EL PASO COUNTY STORMWATER MANAGEMENT PLAN CHECKLIST

STORMWATER ENTERPRISE		VEHICLE TRACKING CONTROL	
ISSUED: 10/7/19	REVISED: 8/19/2020	DRAWING NO: 900-VTC

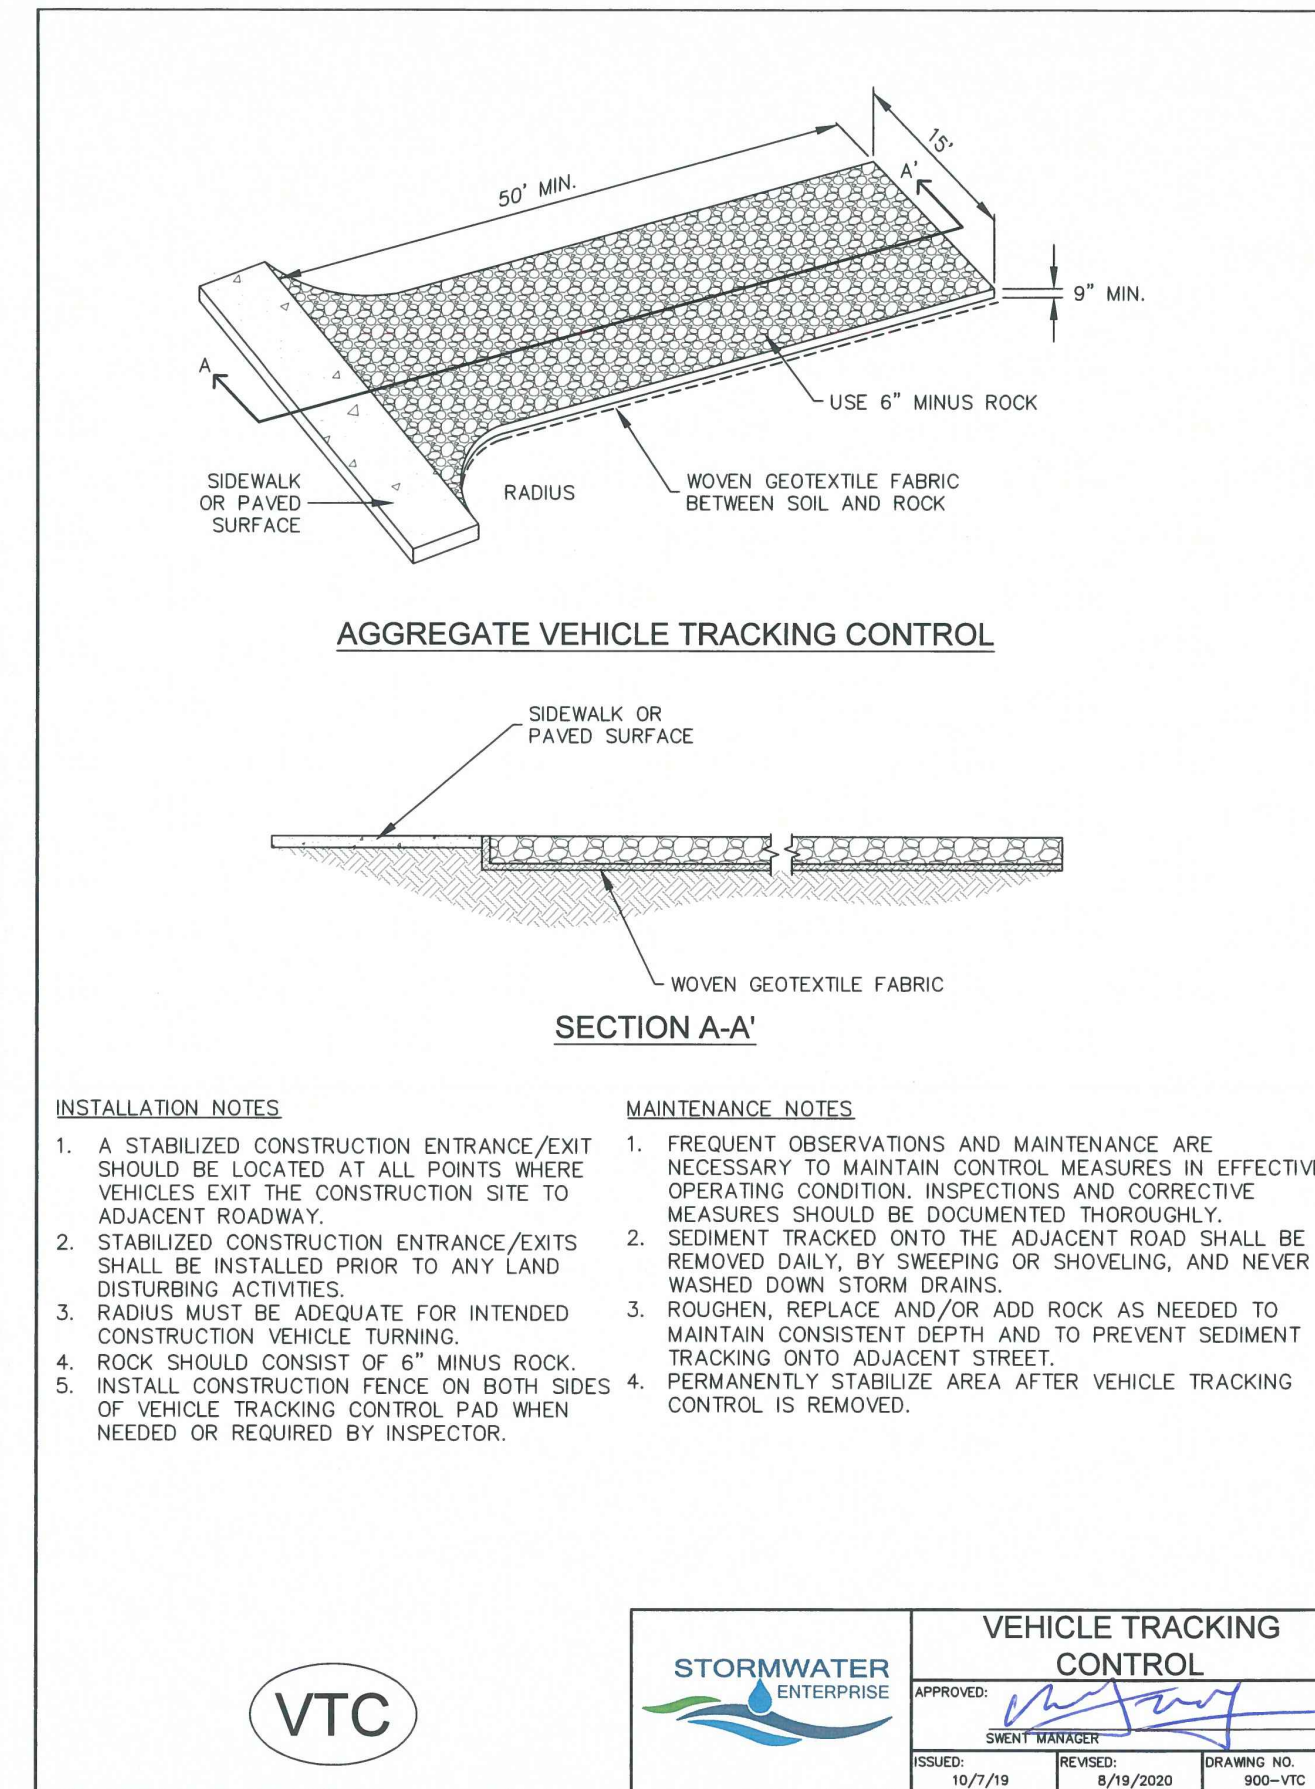
20	Technical drawing details for all control measure installation and maintenance; custom or other jurisdiction's details used must meet or exceed EPC standards	Update VTC detail	N
21	Procedure describing how the SWMP is to be revised		N
22	Description of Final Stabilization and Long-term Stormwater Quality (describe nonstructural and structural measures to control SW pollutants after construction operations have been completed, including detention, water quality control measure etc.)		Y
23	Specification that final vegetative cover density is to be 70% of pre-disturbed levels		N
24	Outline of permit holder inspection procedures to install, maintain, and effectively operate control measures to manage erosion and sediment		Y
25	Record keeping procedures identified to include signature on inspection logs and location of SWMP records on-site		N
26	If this project relies on control measures owned or operated by another entity, a documented agreement must be included in the SWMP that identifies location, installation and design specifications, and maintenance requirements and responsibility of the control measure(s)		Y
